DECISION DELEGATED TO DEVELOPMENT MANAGER

Application No: H03-1119-19 **Applicant:** Mr & Mrs N Watts

Proposal: Details of surface water drainage, external materials, doors and windows and landscaping (Conditions 4, 6, 7 and 10 of H03-1291-16 New farm shop, tea room, car parking and access)

Location: Vine House Farm Bird Foods Vine House Farm Main Road

Window and Door Details - proposed			drawing
1:10 @ A1	scale	October 2019	date
268 - V - 6			drawing no.

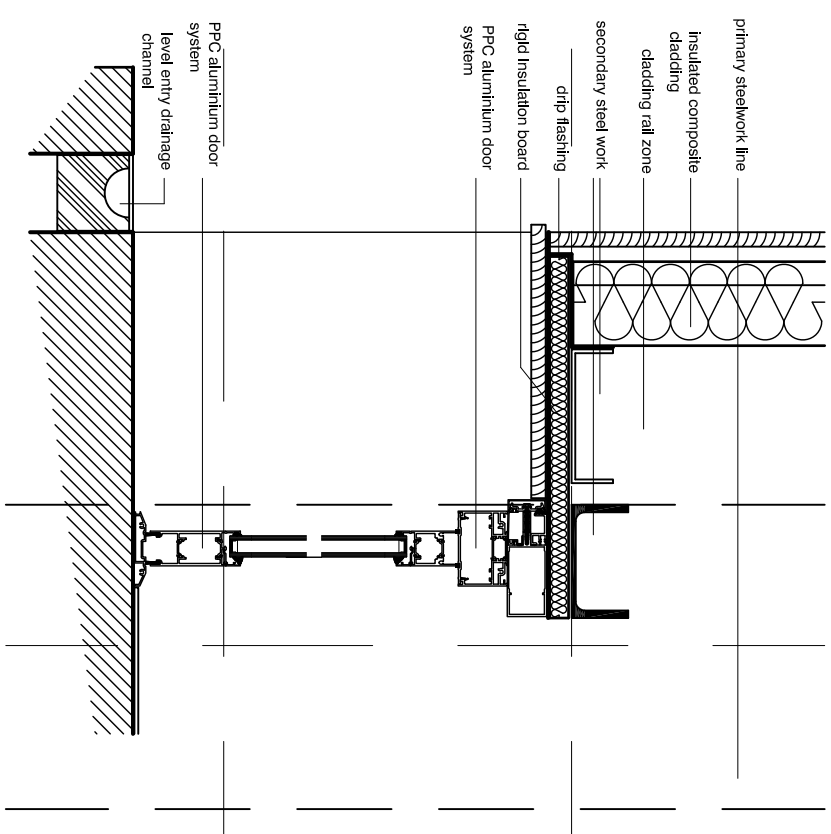
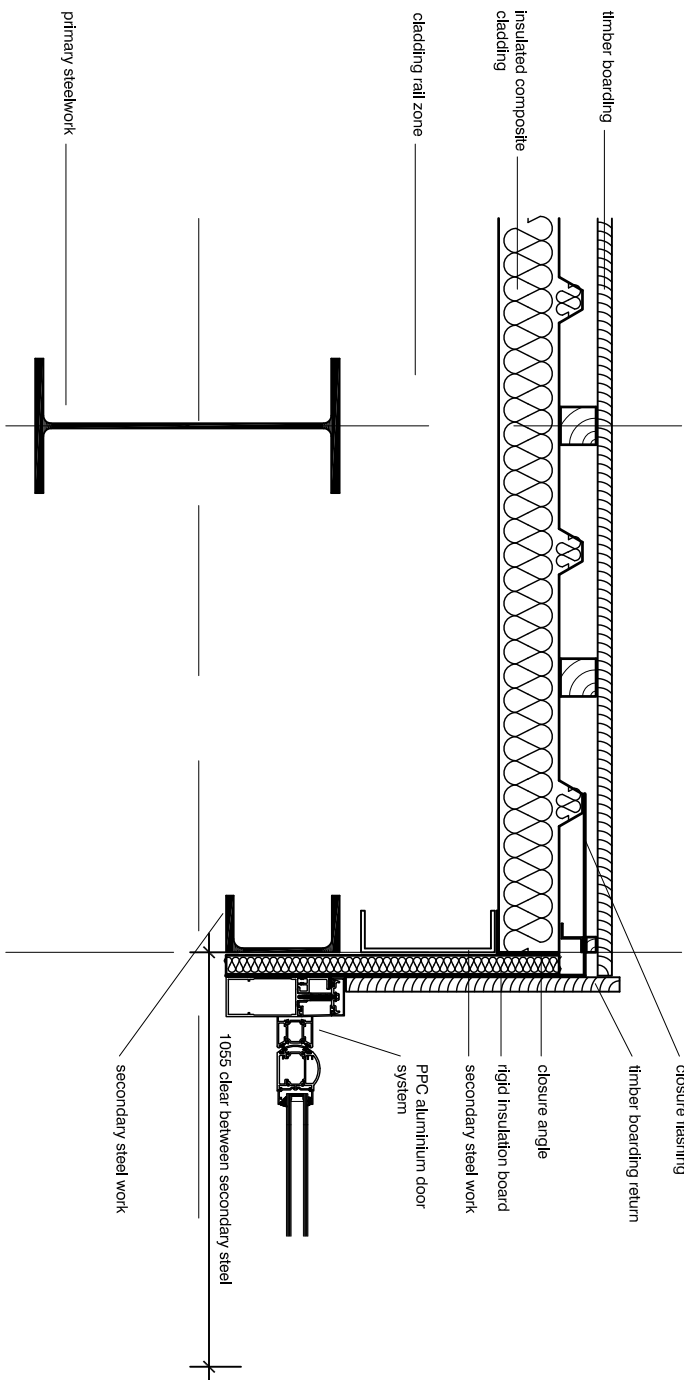
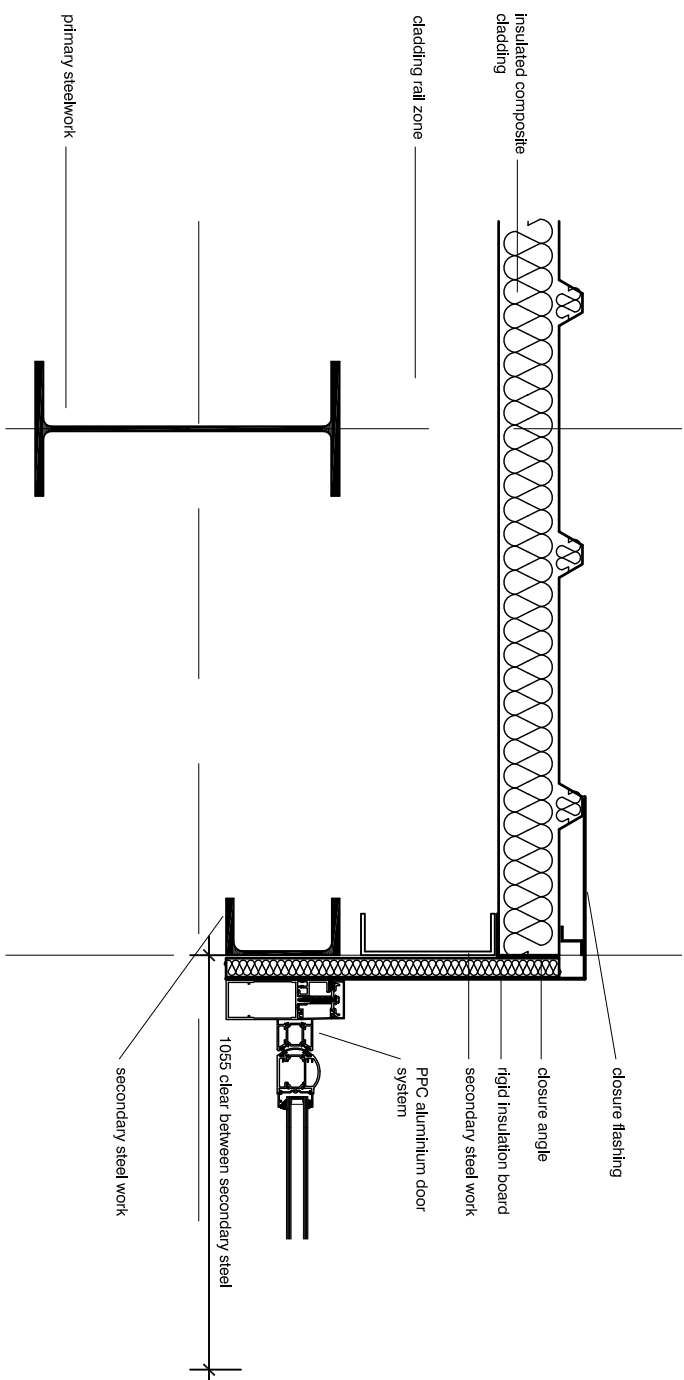
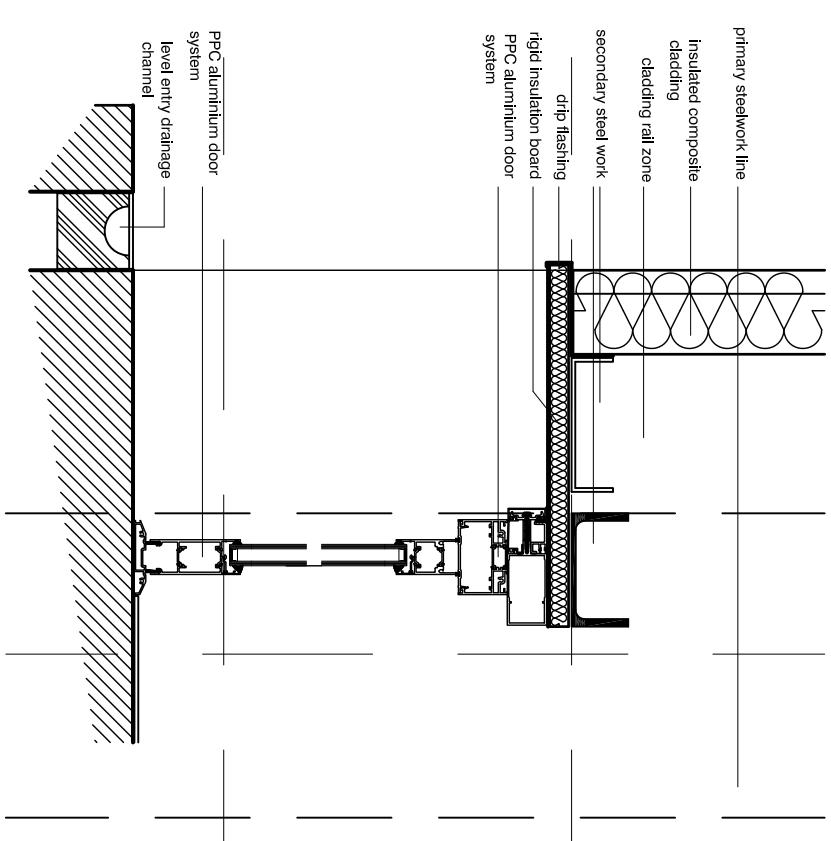
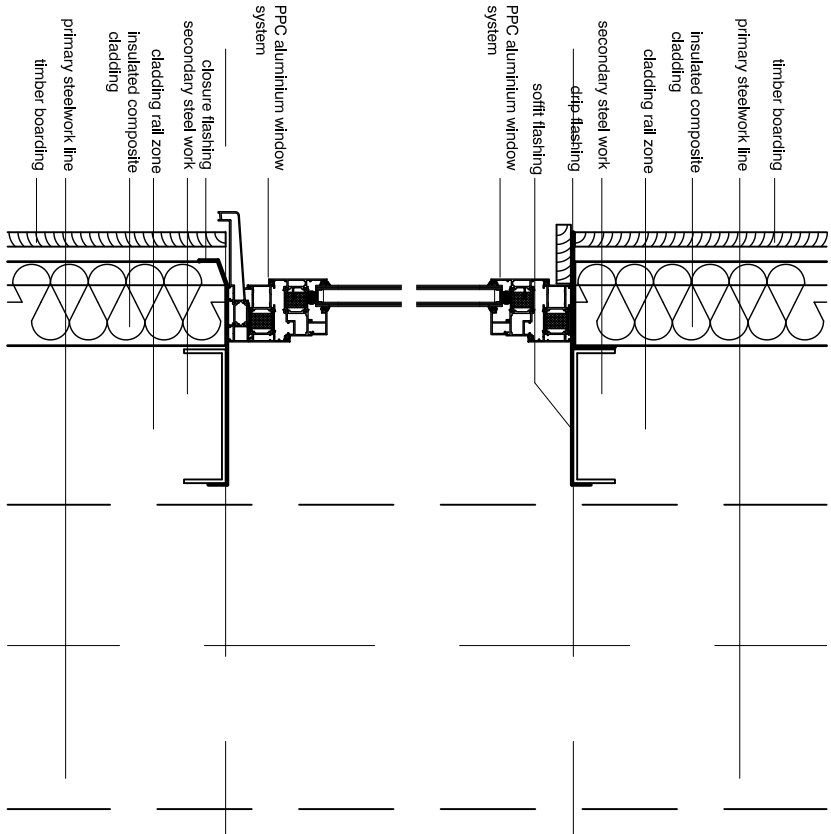
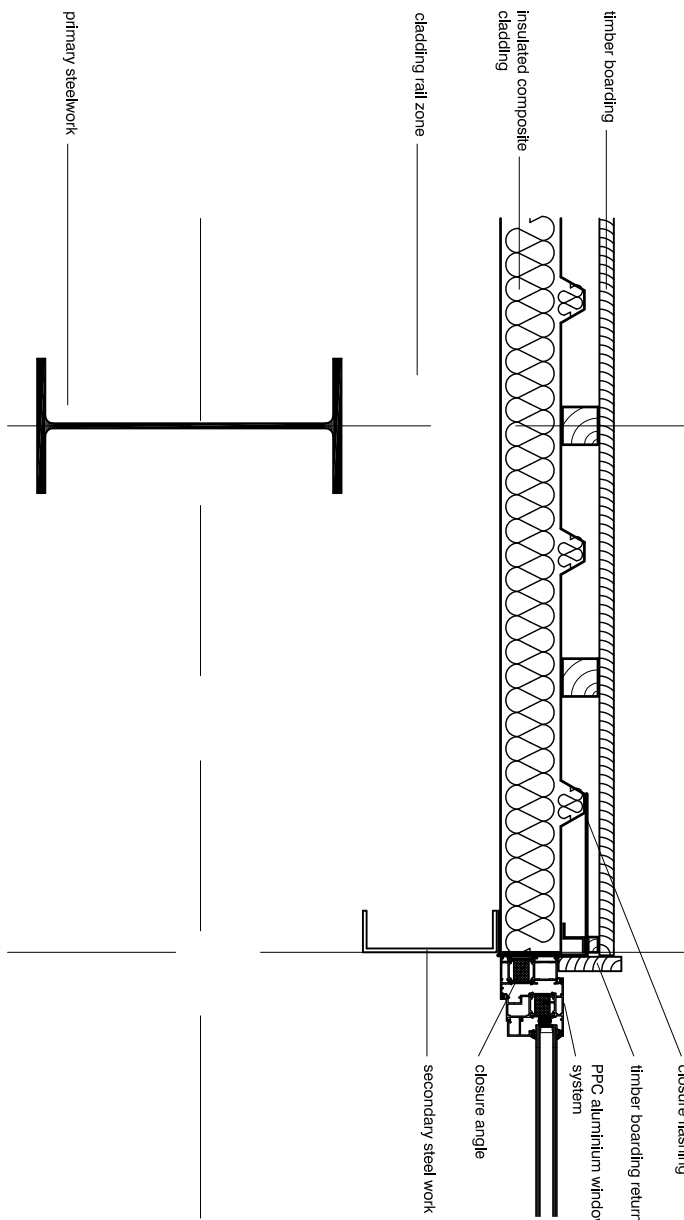
Details of the design of all external doors and the door and window frames to be utilised in the development hereby permitted shall be submitted to and approved in writing by the Local Planning Authority prior to their installation. Such details shall indicate, at a scale of not less than 1:10, the longitudinal and cross-sectional detailing (including reveals), threshold, cill and lintol detailing, and means of opening. The doors and the door and window frames shall be installed in accordance with the approved details and thereafter so maintained.

The window and door details submitted indicate a standard black, powder coated PPC aluminium system. This is considered to be acceptable.

Title Proposed Drainage Layout

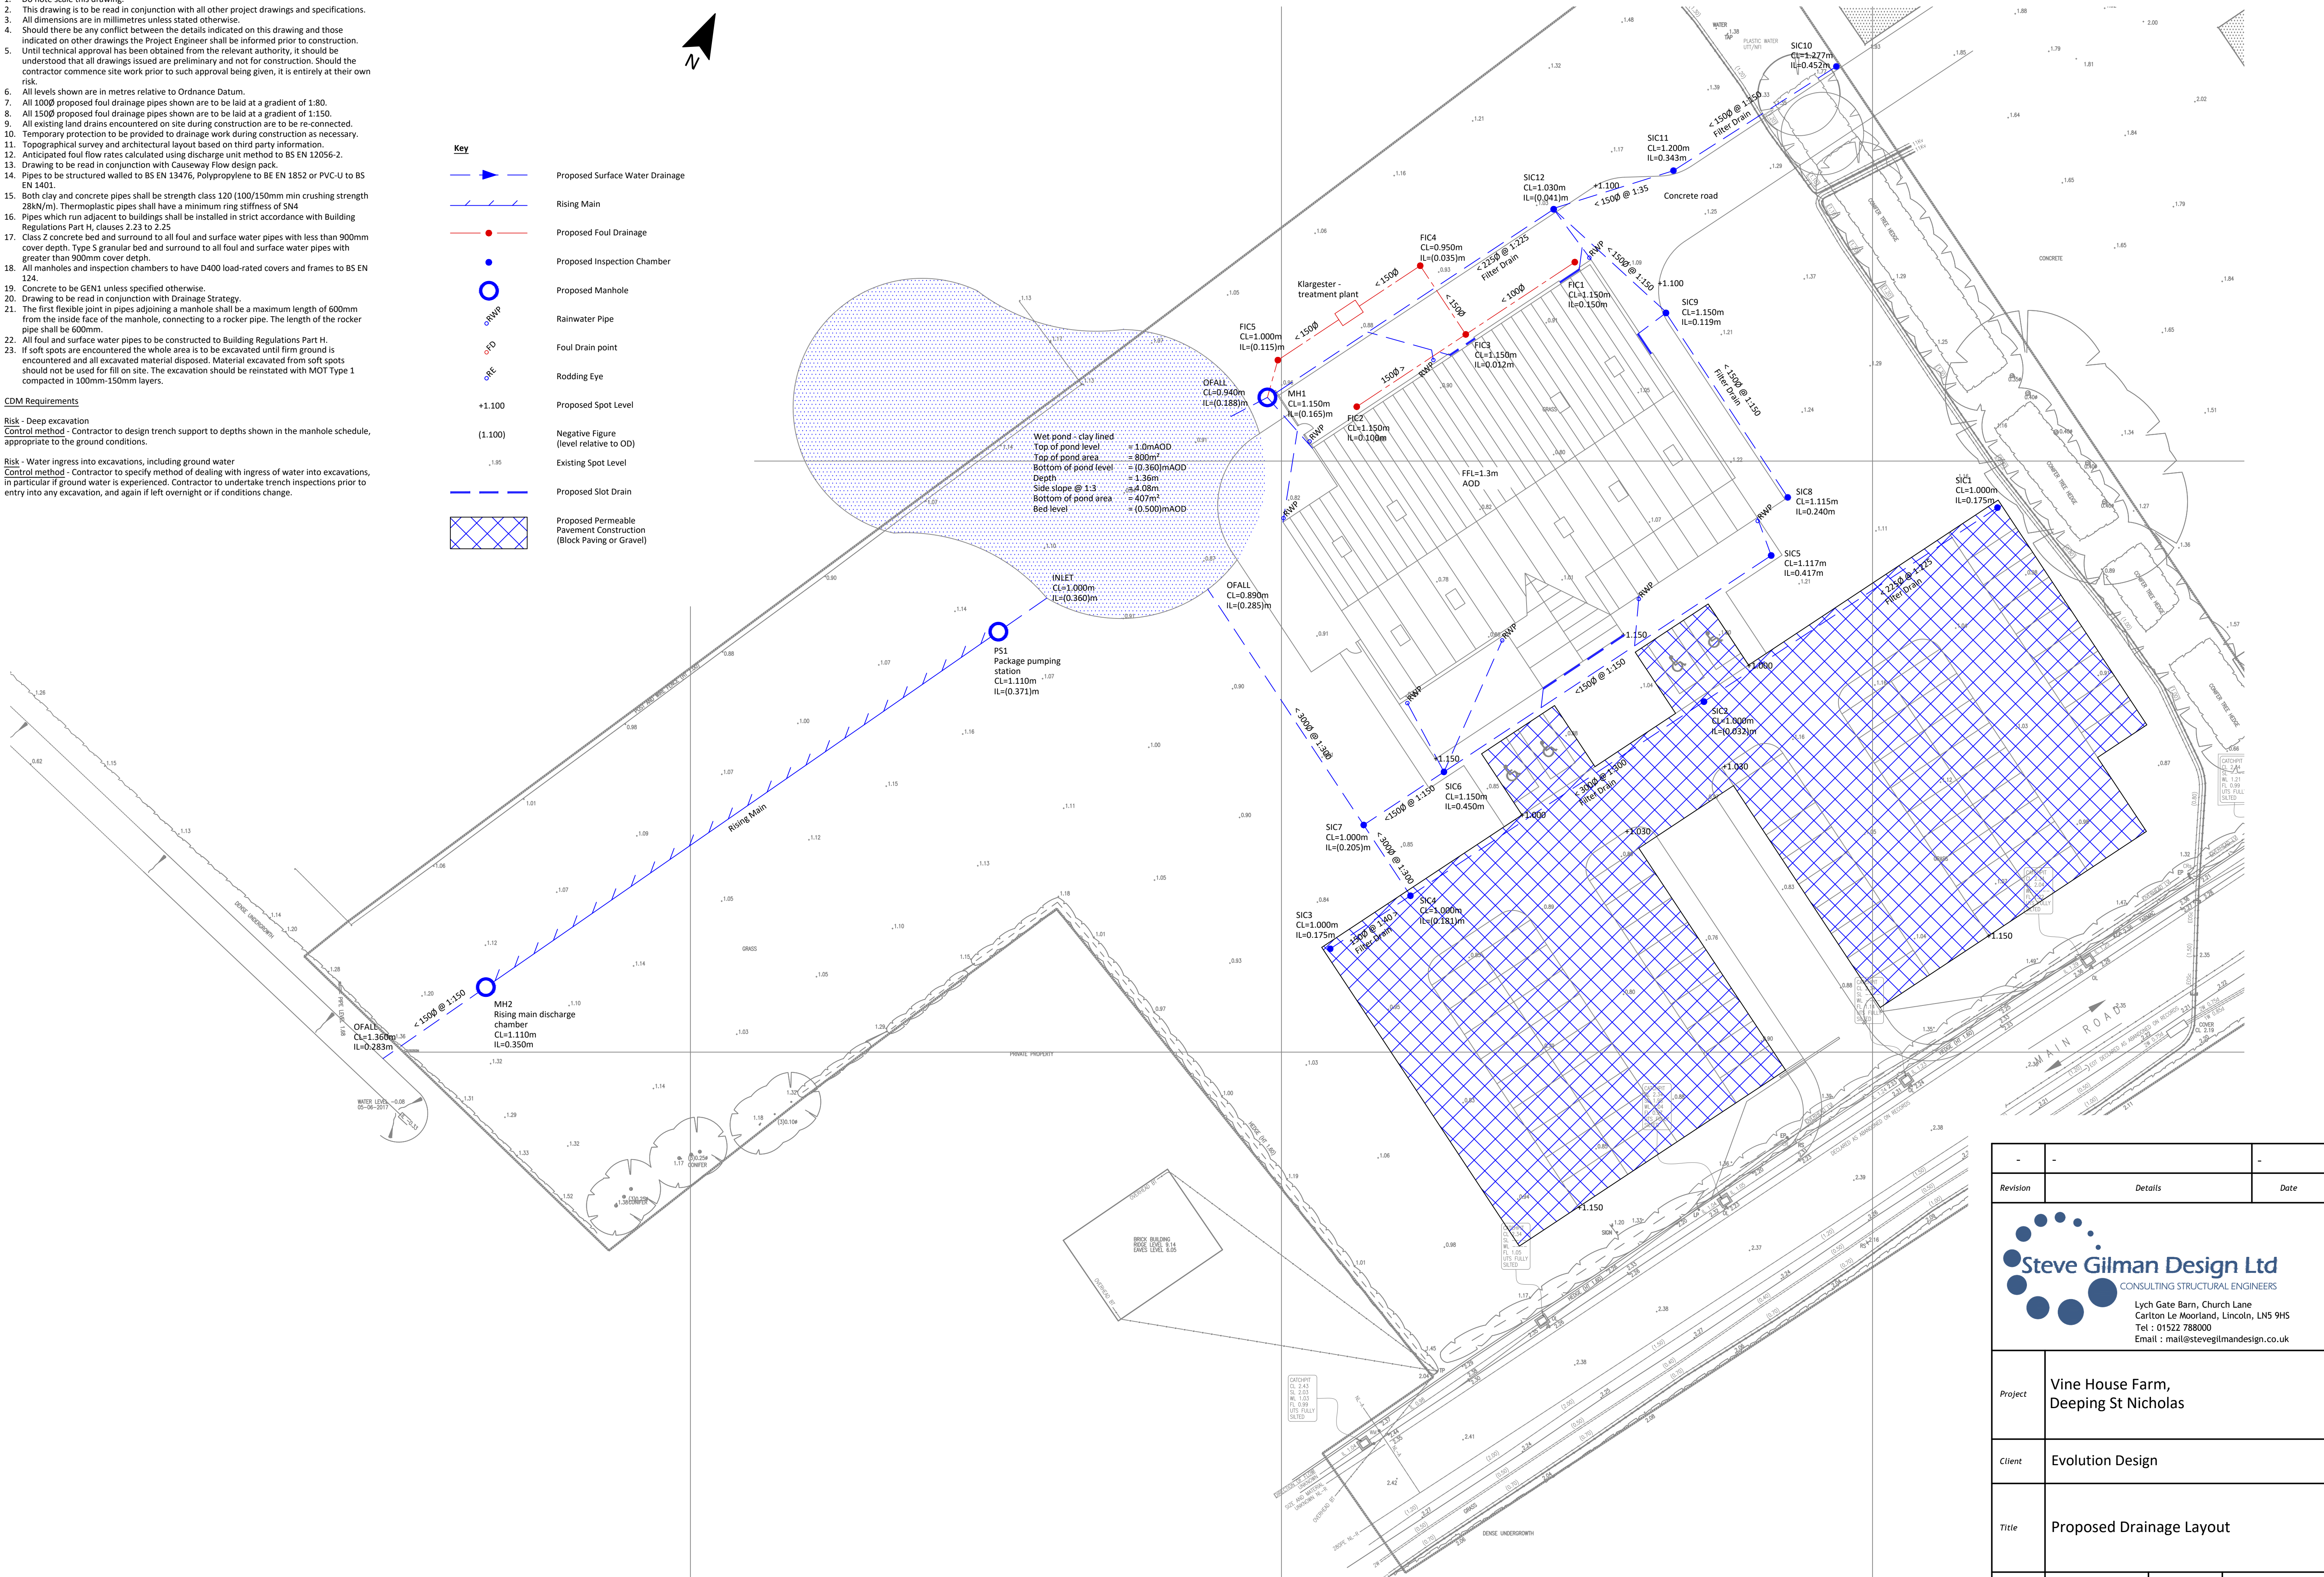
No development shall take place until a surface water drainage scheme for the site, based on sustainable urban drainage principles and an assessment of the hydrological and hydrogeological context of the development, has been submitted to and approved in writing by the Local Planning Authority.

The surface water drainage proposals are considered to be acceptable and no objections have been received.
